Springwell Solar Farm

Responses to First Written Questions (ExQ1)

Doc. Ref. EN010149/APP/8.14
Deadline 1
June 2025
Springwell Energyfarm Ltd

Figure 2 - Aquatic Walkover Habitats Crossing

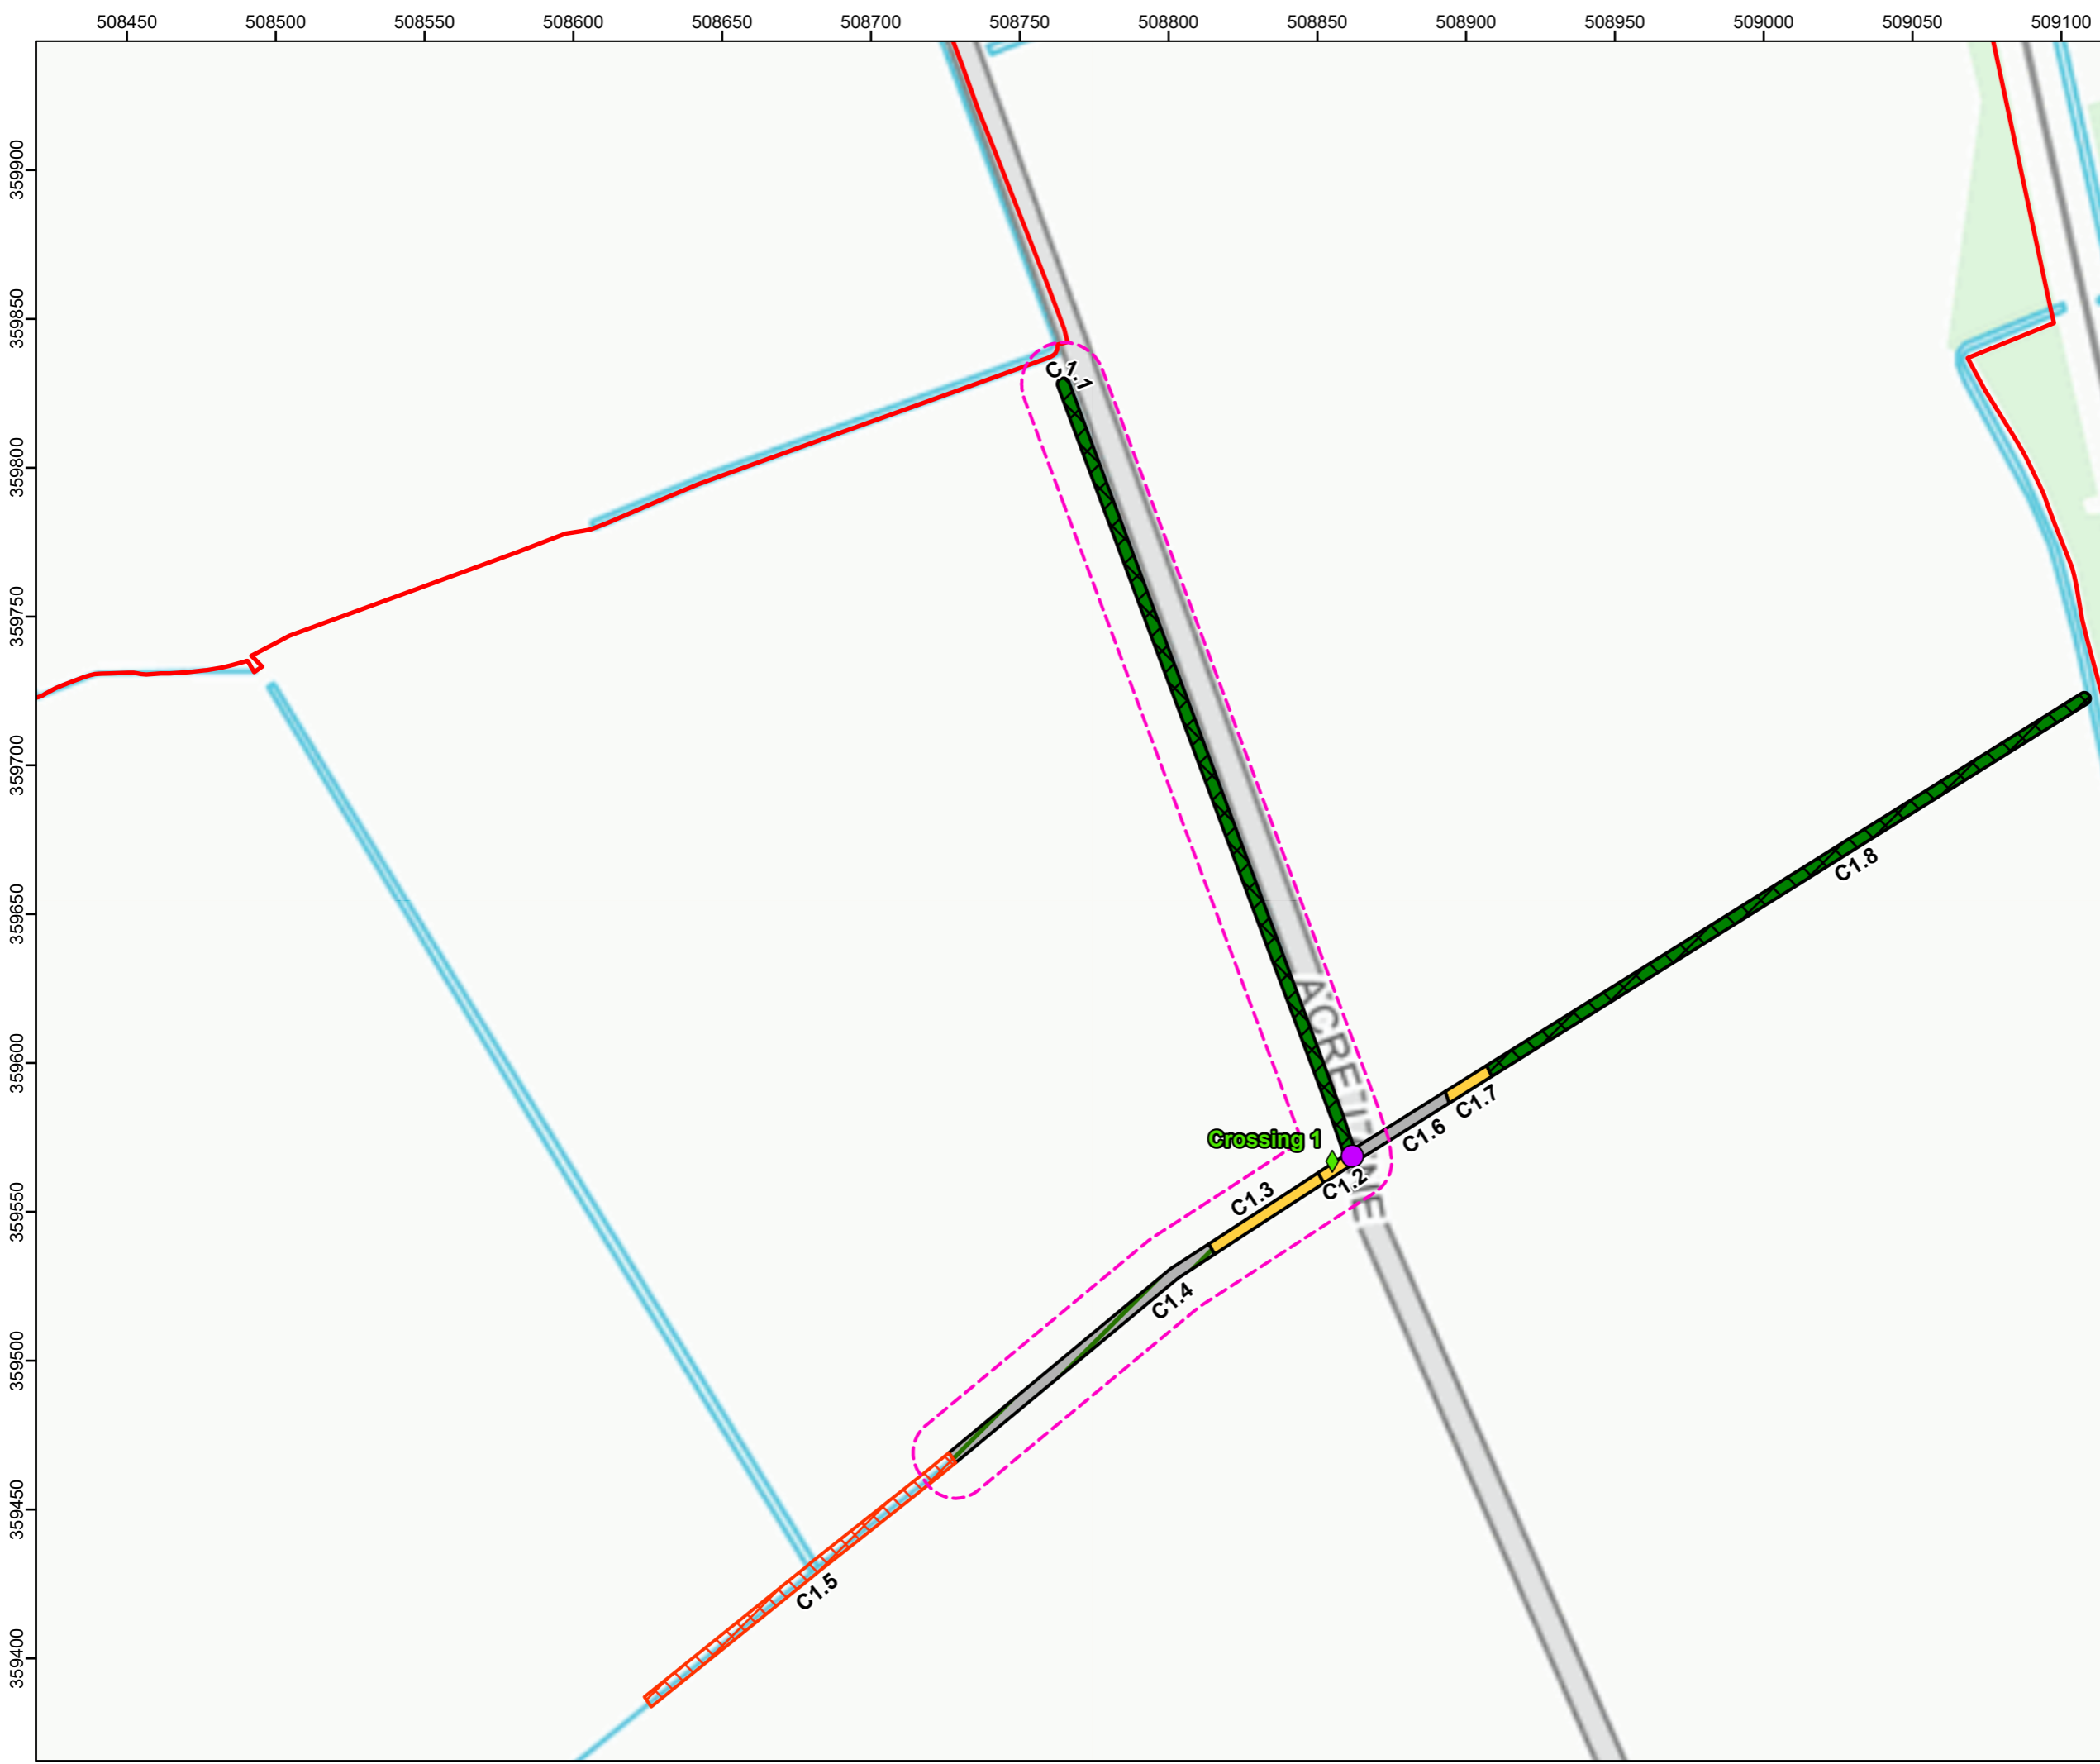
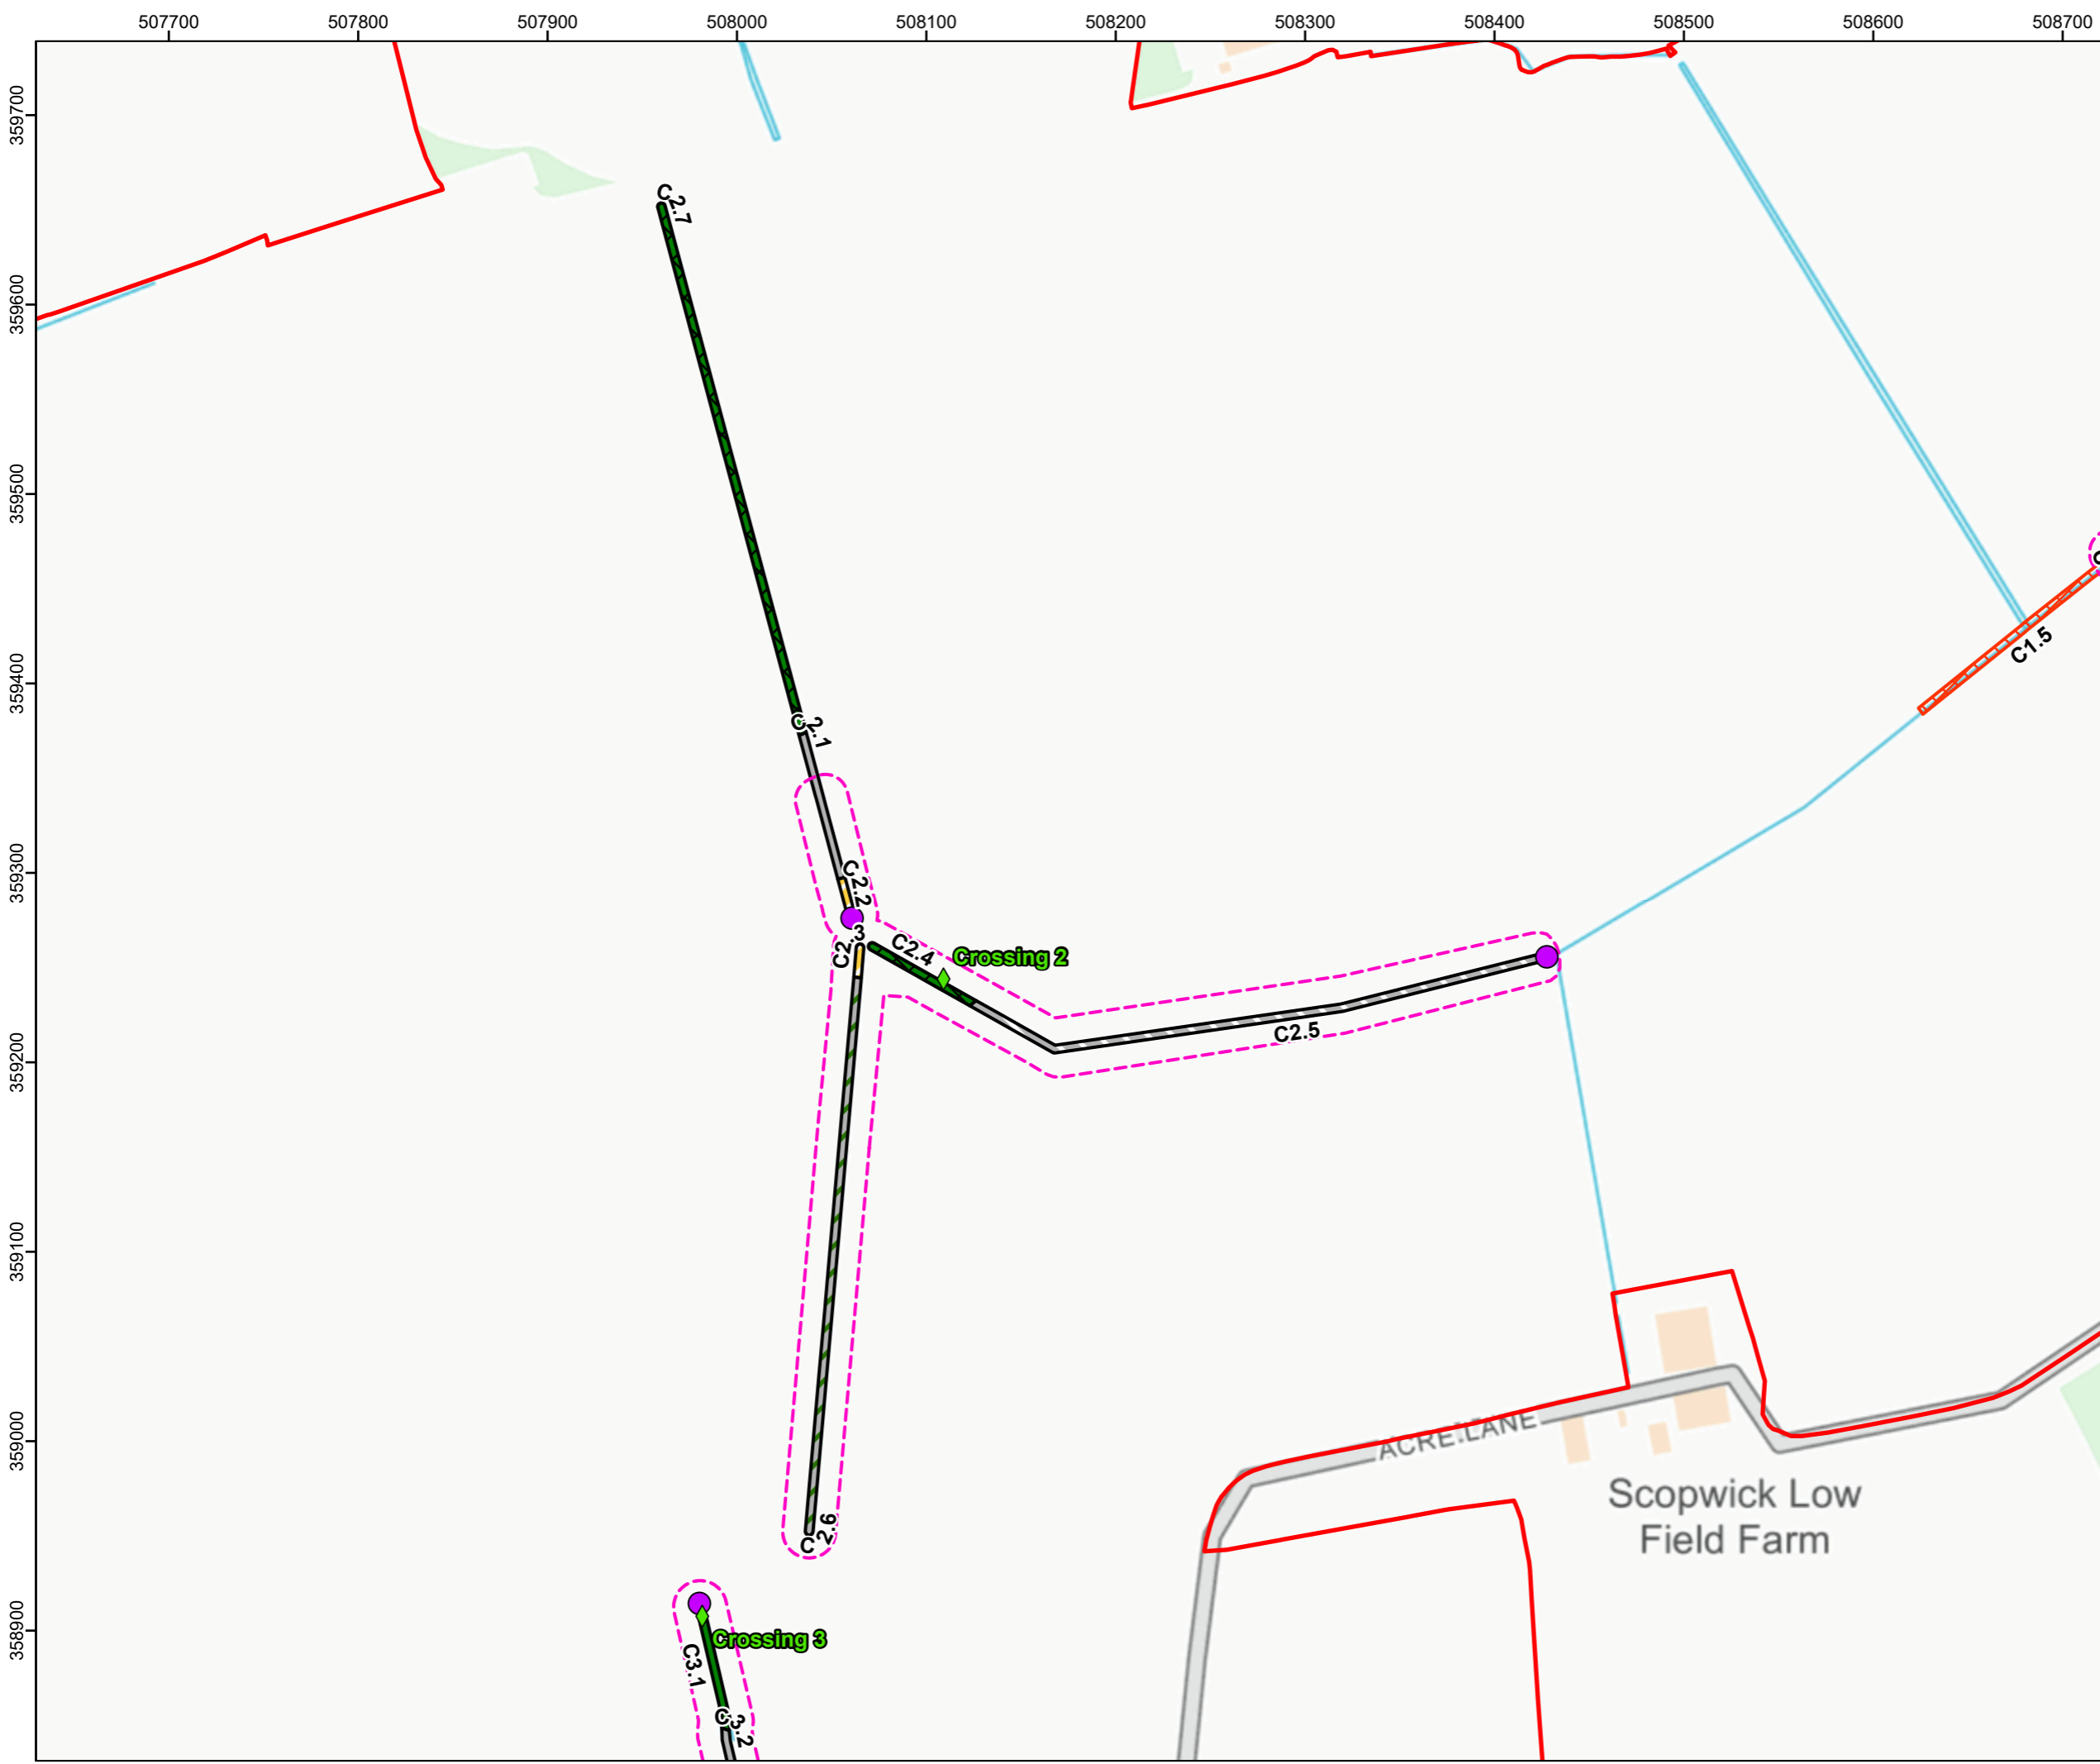
Q1.4.8	<p>Culverting of Watercourses</p> <p>Under the heading of 'Biodiversity, ecological, geological conservation and water management' NPS EN-3 states in paragraph 2.10.87 that culverting existing watercourses/ drainage ditches should be avoided.</p> <p>The ES [APP-047] states that six sections of ditches which will need culverting for internal access road bridges or are in close proximity to</p>	<p>Internal access tracks within the Site will follow the alignment of existing agricultural tracks and, following further review, there is now no requirement for new drainage ditch crossings. There are several existing ditch crossings across the Site which are proposed to be used to facilitate access across the Proposed Development. A further review of ditch crossings has been undertaken and this is detailed below within Table 1 and should be read in conjunction with ES Volume 3, Figure 3.15: Indicative Watercourse and Ditch Crossings [EN010149/APP/6.2.2] [APP-060]. These commitments are secured within the oCEMP [EN010149/APP/7.7.2] which has been updated at Deadline 1.</p> <p>Crossing Point</p>

ExQ1 Ref	Question	Applicant Response
	proposed works. The Riparian Mammal and Aquatic Habitat Assessment Survey [APP-088] concluded that use of the surveyed ditches as temporary refuge and foraging habitat cannot be entirely discounted. In accordance with paragraph 2.10.88 of NPS EN-3, demonstrate that no reasonable alternatives exist to the culverting of these ditches?	<p>1 (located in the south west corner of Field By28)</p> <p>There is an existing culvert and farm track in this location which would be used to facilitate access. The ditch crossings would have a condition survey completed prior to any works taking place. Where there are assets, e.g. existing culverts, any required repairs, remediation or replacement would take place in accordance with the oCEMP [EN010149/APP/7.7.2] , which has been amended at Deadline 1.</p> <p>2 (located in the north west corner of Field Lf02)</p> <p>There is an existing culvert and farm track in this location which would be used to facilitate access. The ditch crossings would have a condition survey completed prior to any works taking place. Where there are assets, e.g. existing culverts, any required repairs, remediation or replacement would take place in accordance with the oCEMP [EN010149/APP/7.7.2], which has been amended at Deadline 1.</p> <p>3a and 3b (located in the northern corner of Field Bk10)</p> <p>There is an existing culvert and farm track in this location which would be used to facilitate access. The ditch crossings would have a condition survey completed prior to any works taking place. Where there are assets, e.g. existing culverts, any required repairs, remediation or replacement</p>

ExQ1 Ref	Question	Applicant Response
		would take place in accordance with the oCEMP [EN010149/APP/7.7.2] , which has been amended at Deadline 1.
		4 (located in the southern corner of Field Bk04) There is a reasonable alternative for access to this location and therefore, this ditch will not be culverted. This is secured within the oCEMP [EN010149/APP/7.7.2] , which has been amended at Deadline 1.
Q1.4.9	<p>Protected Species Licences</p> <p>The ES states [APP-047, Paragraphs 7.8.11 and 7.9.24] that any loss of bat roosts would be mitigated and compensated under a European Protected Species licence from Natural England (NE). NE [RR-291] state that it is unable to provide a position on the likelihood of a licence being granted without having reviewed a draft licence application.</p> <p>Is it proposed that a draft licence application will be made to NE within the timescales of the examination?</p>	<p>On the basis of surveys carried out and the scheme design as discussed below, it is considered low risk that a European Protected species licence would be required, bats being the only European protected species for which one might be required, as justified below.</p> <p>Surveys of woodlands, adjacent to where hedgerows and trees will be directly affected, indicates that the woodlands are not suitable for significant bat roosts (as trees lack suitable features). Also, the bat activity data does not indicate any significant bat roosts near to where hedgerows are to be removed for highways access as no bat calls were recorded shortly after their anticipated emergence times.</p> <p>Also, the scheme design has avoided removal of trees identified with significant potential to support roosting bats, based on the ground level roost assessments undertaken. Any trees that do require removal are only likely to have up to low potential to support roosting bats – these would be subject to survey (either climbing or emergence) before felling and in the unlikely event that bats are found a licence would be applied for and mitigation agreed with Natural England. As the trees are considered of negligible or low bat roosting potential no significant roosts are anticipated to be affected. It is important to note that there is no benefit in doing climbing or emergence surveys now of trees with low bat roost potential as bat usage of tree roosts is transitory, i.e. they often switch roosts on a daily basis, and we would therefore have to re-do the survey work immediately before construction.</p>
